**Parramatta Powerhouse  
Response to Further Submissions – Mod 1 to State Significant Development Consent SSD-10416**

We write on behalf of Infrastructure NSW (the Proponent) in relation to the Section 4.55(1A) Modification Application (MOD 1) to the Powerhouse Parramatta project (SSD-10416) at 34-54 and 30B Phillip Street and 338 Church Street, Parramatta (the site). This letter sets out the Proponent's response to further submission provided by the City of Parramatta Council in response to the Submissions and Amendment Report. A detailed response to Council's letter is provided at **Attachment A**.

4 PROPOSED ELEVATION W  
1 : 100

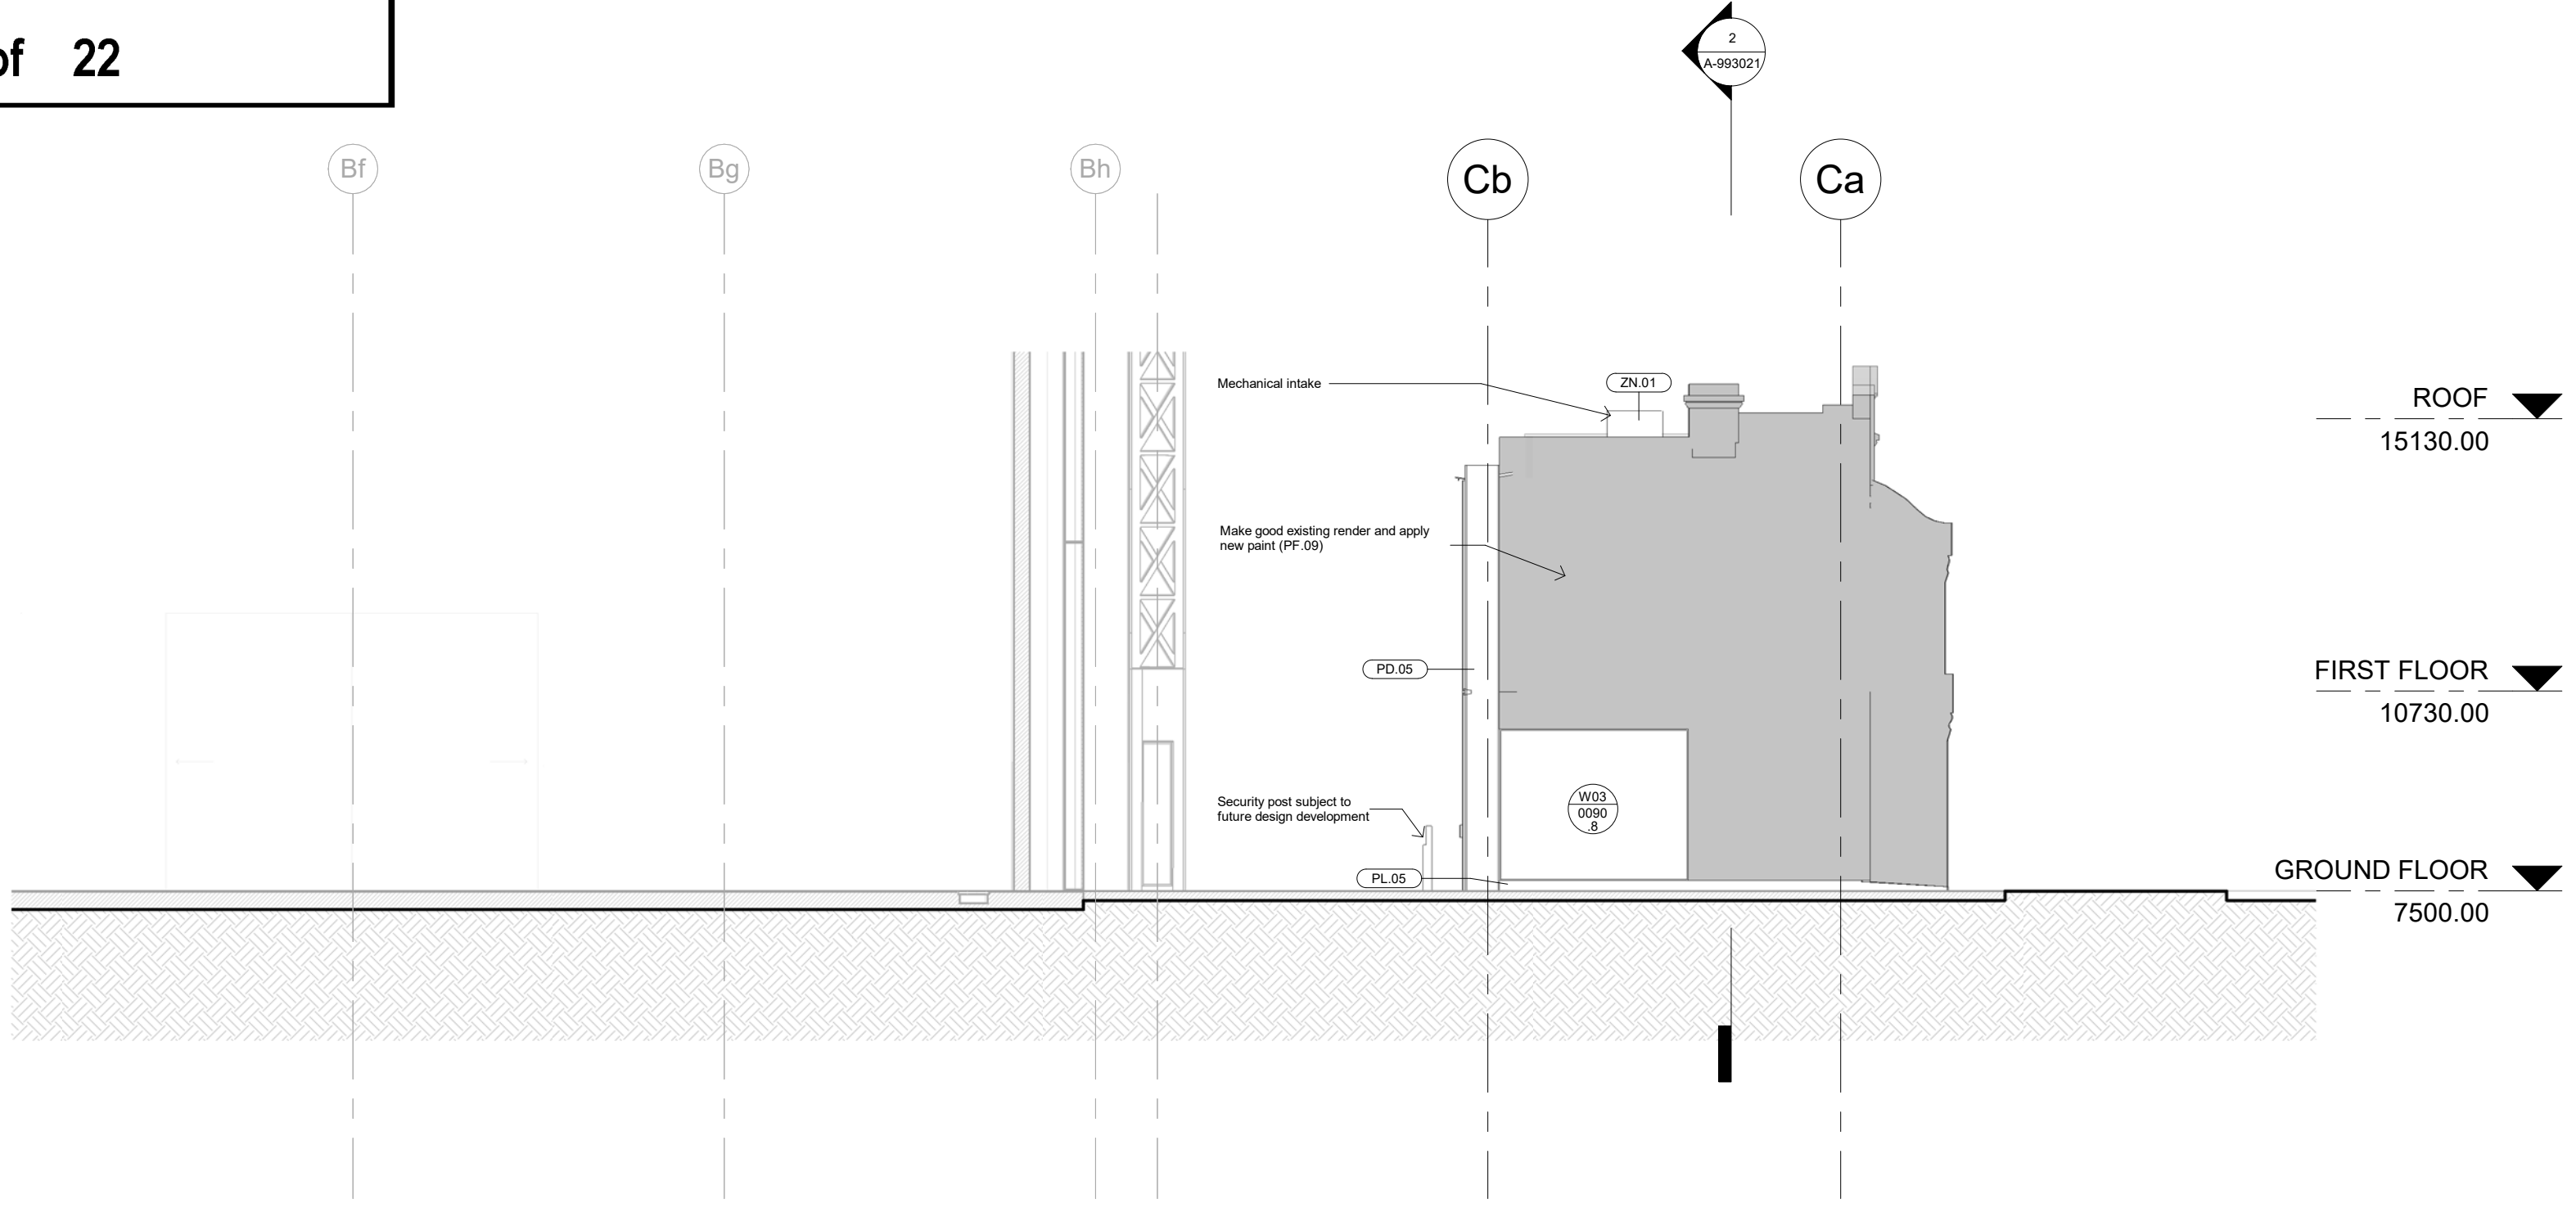
COPC16	2. The window and door openings should be reinstated to the original proportions, including the removal of the brick window infills.	The Applicant has considered Council's comment and will commit to reinstating the original proportion of openings with window/door arrangements that would represent the original fabric whilst maintaining current building standards and maintaining the design integrity of Powerhouse Parramatta.
COPC17	3. Fill or reconstruct the additional opening spaces at ground level that were created to convert each terrace into a commercial business with shop front incorporating door (between 1970 and 1978). This should be based on historical evidence if any and the use of sympathetic materials compatible with the building's heritage value is recommended.	<p>As outlined, the proposed internal layout is considered to best serve an adaptive reuse of the terrace for Powerhouse Parramatta. The poor existing condition of the terrace reflects its unsuitability for ongoing use as smaller individual spaces. As such the internal walls will be removed.</p> <p>The Applicant commits to reinstating the Phillip Street façade openings to represent that of the original fabric.</p>

COPC27	The applicant is concerned that Council has requested changes to the doors and windows that would appear as an imitation. This is not the case, Council requests a design inspired by the Victorian proportions that would allow an appropriate interpretation of the original façade prior to the unsympathetic 1970s changes. The new elements requested are not supposed to appear as an imitation.	The Applicant has considered Council's comment and will commit to reinstating the original proportion of openings with window/door arrangements that would represent the original fabric whilst maintaining current building standards.
COPC28	The veranda reinstatement would make a significant contribution to the street view and overall heritage preservation. St George Terraces are a rare example of its typology of terraces within the Parramatta LGA and Parramatta CBD and should be restored to its maximum potential.	<p>The reinstatement of the first floor verandahs is not considered feasible or warranted. Access to the verandahs would not be possible with the proposed internal design that is required in order to ensure the functional adaptive reuse of the Terrace for the Powerhouse Parramatta.</p> <p>The Applicant has already committed to reinstatement of the plaster urns as part of the Response to Submissions.</p>
